Martin Nugent
01254 828060
D3/12/0420

Drafted 3 July 2012

**Outline Planning Application, Ribble Valley District
3/12/0420 land north and west of Littlemoor Road, Clitheroe**

9W7186 SK016

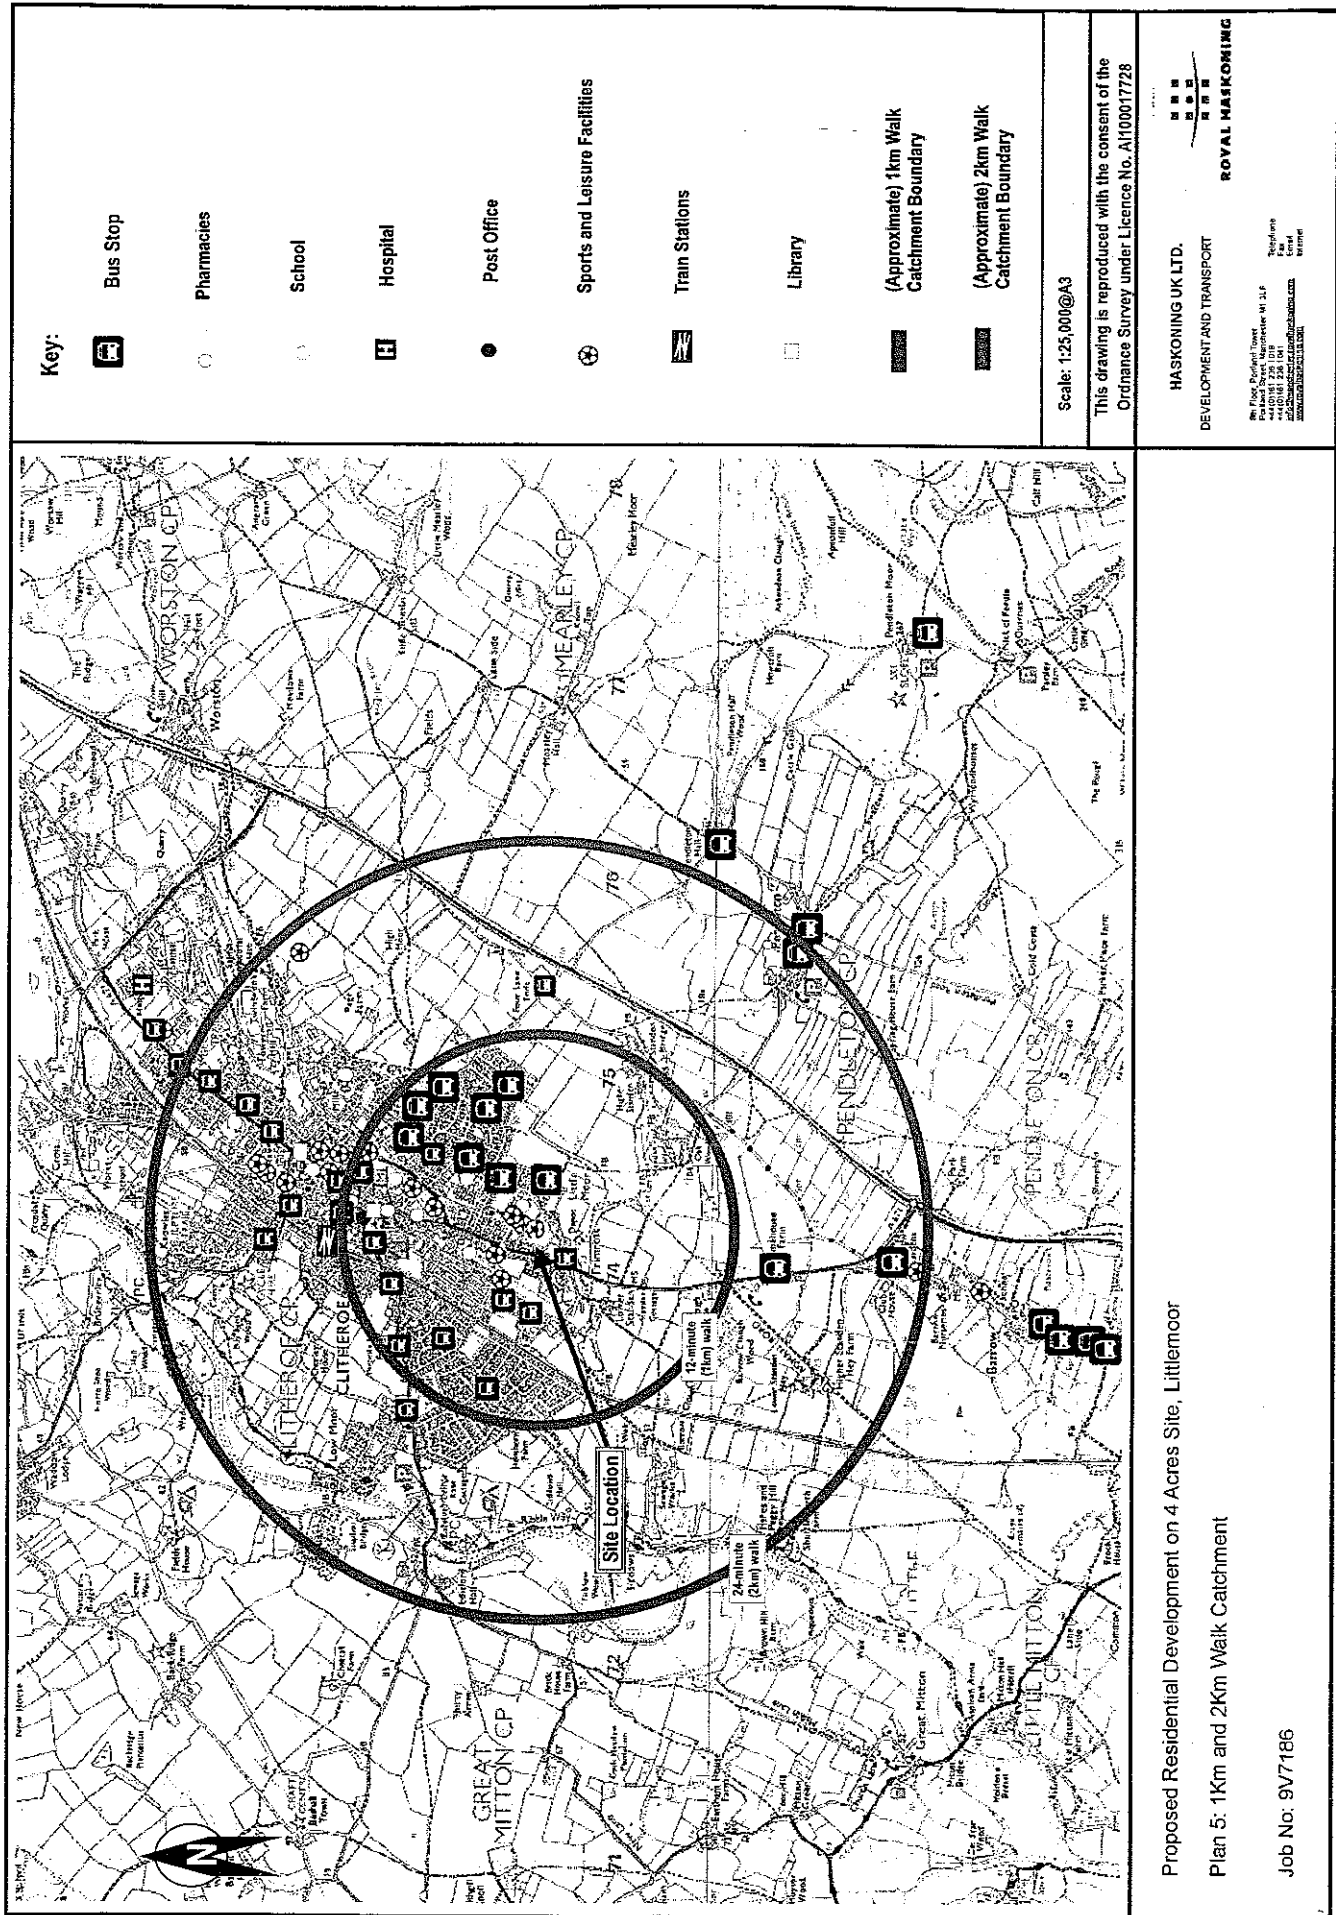
The initial design contained in Drawing 9W7186 SK016 Revision A, provides an indication of the highway parameters for the design of a suitable vehicular access.

The initial access design indicates that visibility splays of 2.4m by 43m can be achieved from the site onto Littlemoor Road. I am satisfied that this is a suitable provision and that it can be achieved in this instance. In addition, the recent implementation of a 20mph Speed Limit on Littlemoor Road will assist with compliance.

However, there are some aspects of the initial site layout that should be revised to enhance highway safety.
